379 Palmer Ave
353 D-00

Porch Construction

| Project description: <u>26' x 6' open porch</u> | | |

Porch Construction

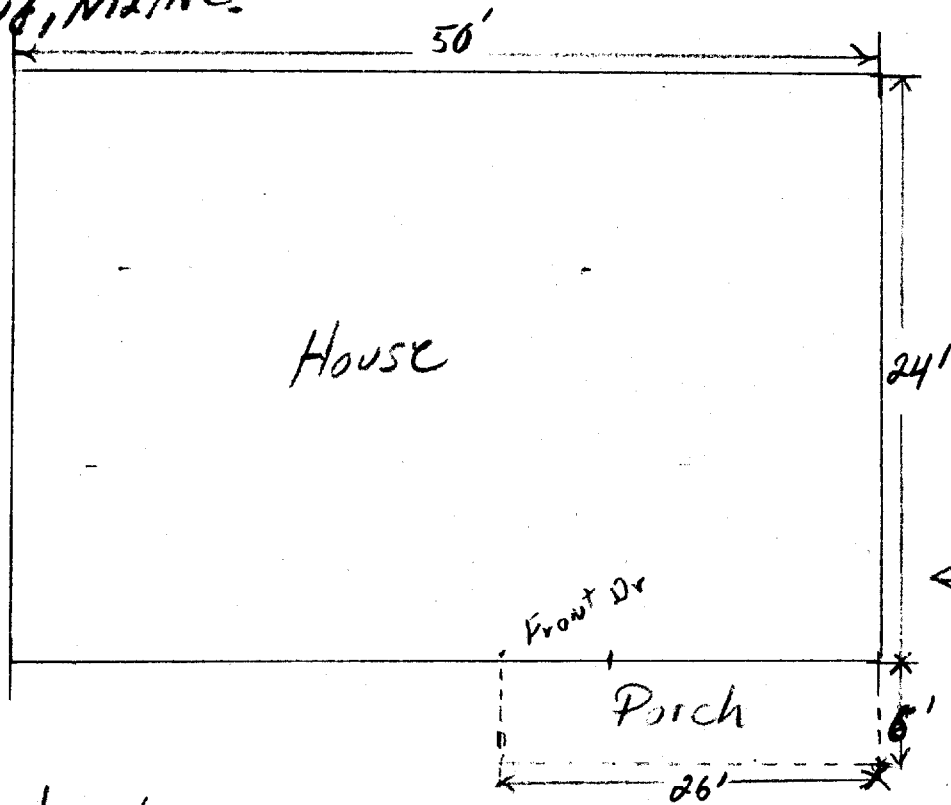
- ① Girder - 2-2x8 or 3-2x6's - 8 1/2' span
- ② Tubes - 4' below grade
- ③ Steps ? - 1 1/2" Rise 11 1/2" Tread -
- ④ Roof ? - Rafter + Girders - 2-2x8 - 6 1/2' span
2x8 Rafter - 16" OC
